RE: Headrick Garage and Pool Addition Watercourse Classification Memo - CAO19-014

Wetland Resources, Inc. (WRI) recently received email correspondence from City of Mercer Island planning staff (date: August 26, 2019, subject line: FW: Headrick Project, CAO19-094&1905-249, Notice of Application for Critical Area Determination) requesting a response to comments made by the Muckleshoot Tribe. The following narrative re-states all comments made by the Muckleshoot Tribes as italicized, indented text, which are immediately followed by the applicant's response as justified, normal text. In short, this memo is intended to present data that supports the applicant's original assertion; that the on-site reach of Stream A does not meet criteria for designation as a fish-bearing watercourse.

Figure 1: Contributing Basin to Stream A

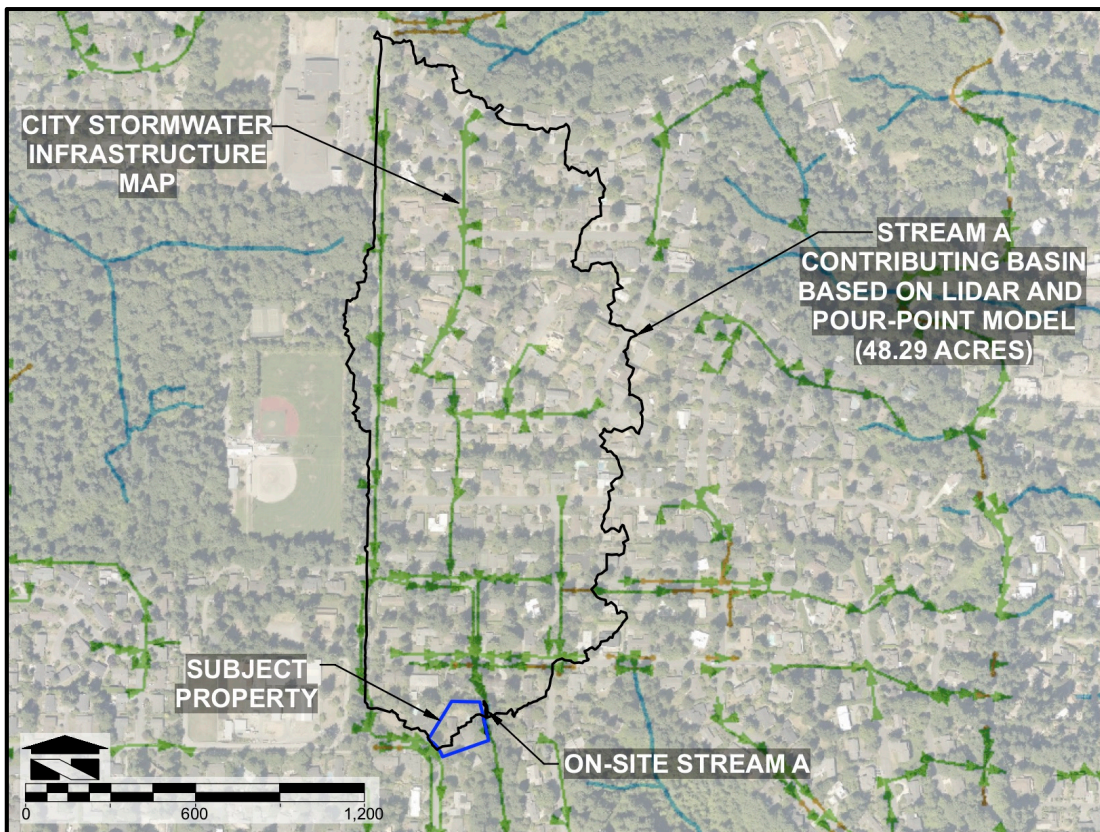
We have reviewed the available information for the Headrick project at 8822 SE 62nd Street, Mercer Island and offer the following comments: The Critical Areas Report is incomplete with respect to stream typing. The report notes that WADNR data was used to determine "fish presence determinations" consistent with the water typing rules set forth in WAC 222-16-030. This statement is inaccurate. WAC 222-16-030 is not in effect yet. The readers are directed to the interim rule in effect under WAC 222-16-031 which includes determinations for streams with potential fish use (Type 3) under 2.b.i. This section states:

Stream A discharges to an 18" PVC culvert in approximately the southeast corner of the property. Based on comparison with the City's stormwater inventory, and by constructing a pour-point model using publicly available LIDAR data, the contributing basin to the on-site portion of Stream A is 48.29 acres in total area.

Figure 2: Existing Site Conditions and Channel Measurement Location

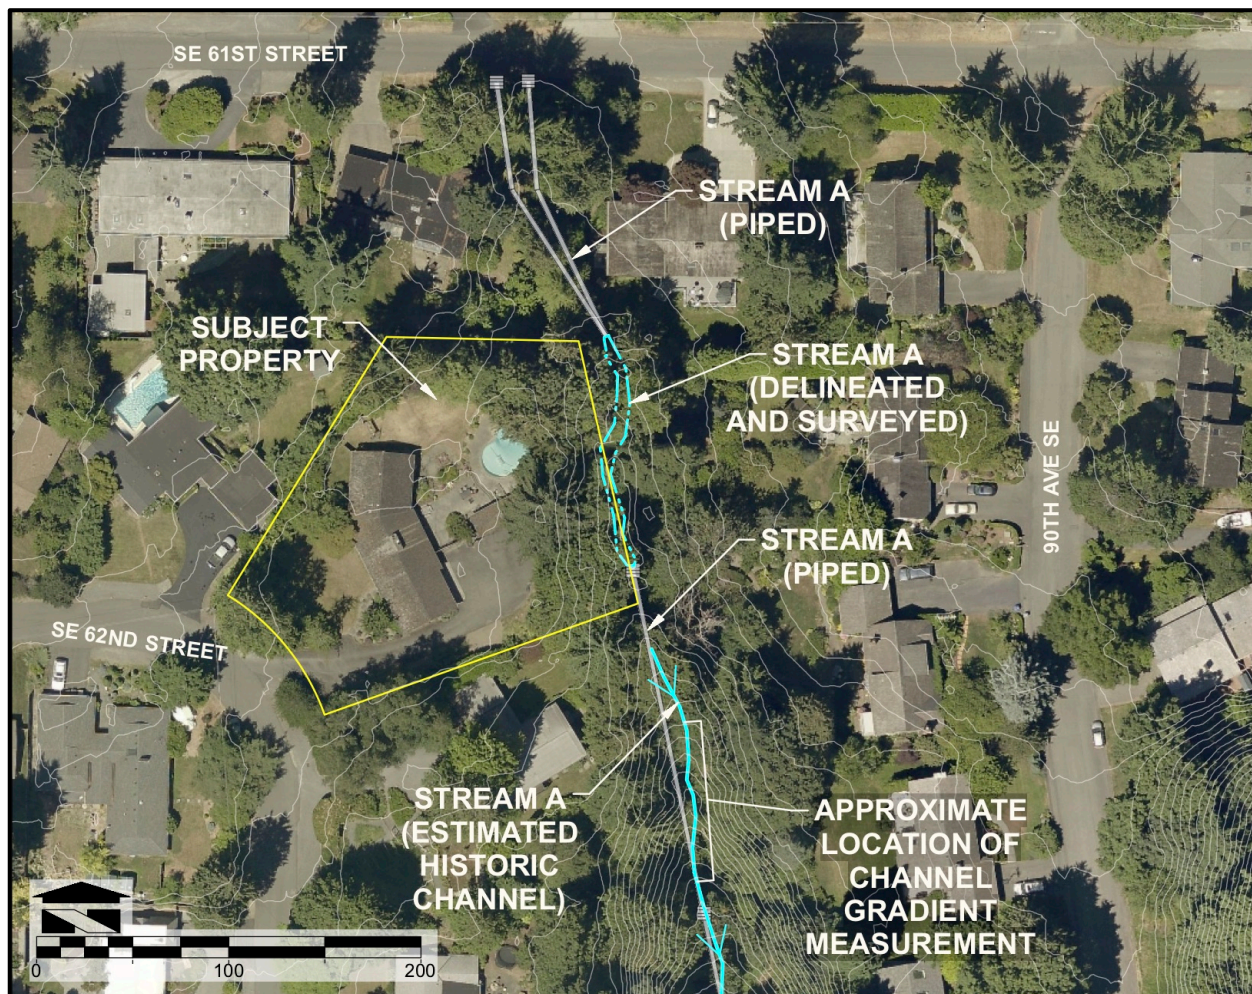
The WDNR maps are tool to make this determination initially; however, in the areas outside of commercial forest production districts, the maps were not developed with field data. Therefore, anyone using the WAC and maps needs to actually collect stream data to demonstrate if the physical criteria from above are met for presumed fish use. Part of this determination means determining if there are any natural barriers downstream. We are unaware of any such barriers but the City may data otherwise. If there are no known natural barriers, then stream data for bankfull width and streambed gradient needs to be collected by measuring 6-10 random samples on site and compare against the physical criteria. If it is met, the Stream is a Type 3/Type F fish bearing water based on presumed use.

From a review of the site plan map showing the locations of the surveyed OHWM, it appears that the stream meets the criteria for bankfull width (i.e. >+2 feet). The streambed gradient is unknown at this time. More data is needed to establish the streams classification.

As previously stated, Stream A enters an 18” culvert located in approximately the southeast corner of the subject property. Based on the City’s stormwater inventory, that pipe daylights to an open channel several properties to the south (6250 89th Ave SE). Due to evidence of steep topography (exceeding 20 percent) using LIDAR-based elevation contours, channel gradient measurements were taken in the field within the adjacent property located at 6206 89th Ave SE, to determine stream gradient. Steep topography was physically observed in the historic channel of Stream A, similar to the findings of the LIDAR-based slope assessment. Figure 2 below depicts the location where historic stream channel gradient measurements were taken. The enclosed Watercourse Classification Maps also depict the location of field measurements.

Using a Suunto clinometer, surveyor’s rod (long fiberglass pole), and a 100-foot measuring tape, WRI staff conducted a channel gradient measurement in the field. This area was selected for field measurement based on a WRI analysis of elevation contours generated from publicly available LIDAR data that indicated a continuous slope exceeding 20 percent gradient for at least 88 horizontal feet. Due to the presence of dense, sight-obscuring vegetation, and limited site access, channel gradient was measured in two segments. The first segment was 55 feet in length (parallel to the sloping ground surface) and began at the lowest point of the historic channel. The second segment was 35 feet in length along the ground surface. Each segment was measured using the following method.

Each segment, as measured in the field, showed a slope angle of 21 degrees. Using basic trigonometry, it was determined that the horizontal distance of the first segment (55 feet along a 21° slope) equals 51.3 feet, and that the horizontal distance of the second segment (35 feet along a 21° slope) equals 32.7 feet. Therefore, a continuous 21° slope was physically observed for a total horizontal distance of 84 feet. Farther downstream of the measurement location, channel gradient appeared to become less steep. Above the upstream limits of measurement, slope appeared to be as steep or steeper than the measured segments. Based on the total area of the contributing basin (48.29 acres), and the observed 21° slope, the on-site portion of Stream A does not meet any of the presumption-of-fish thresholds established in the WAC. Stream A is correctly classified as a Type III/Type Ns watercourse in the vicinity of the subject property.

Applicant's response: The on-site portion of Stream A meets the criteria for bankfull width, but is upstream of a natural fish passage barrier according to the WAC (greater than 16 percent slope in with a contributing basin less than 50 acres), and an artificial fish passage barrier (culvert under E Mercer Way). See detailed discussion above. In the vicinity of the subject property, Stream A is correctly classified as a Type 3/Ns stream pursuant to the water typing rules of WAC 222-16-031, and pursuant to the rules in effect at the time of complete application for the current project. In the vicinity of the project, current and future development should not be subject to regulatory setbacks associated with fish-bearing streams based on the findings of this memo.
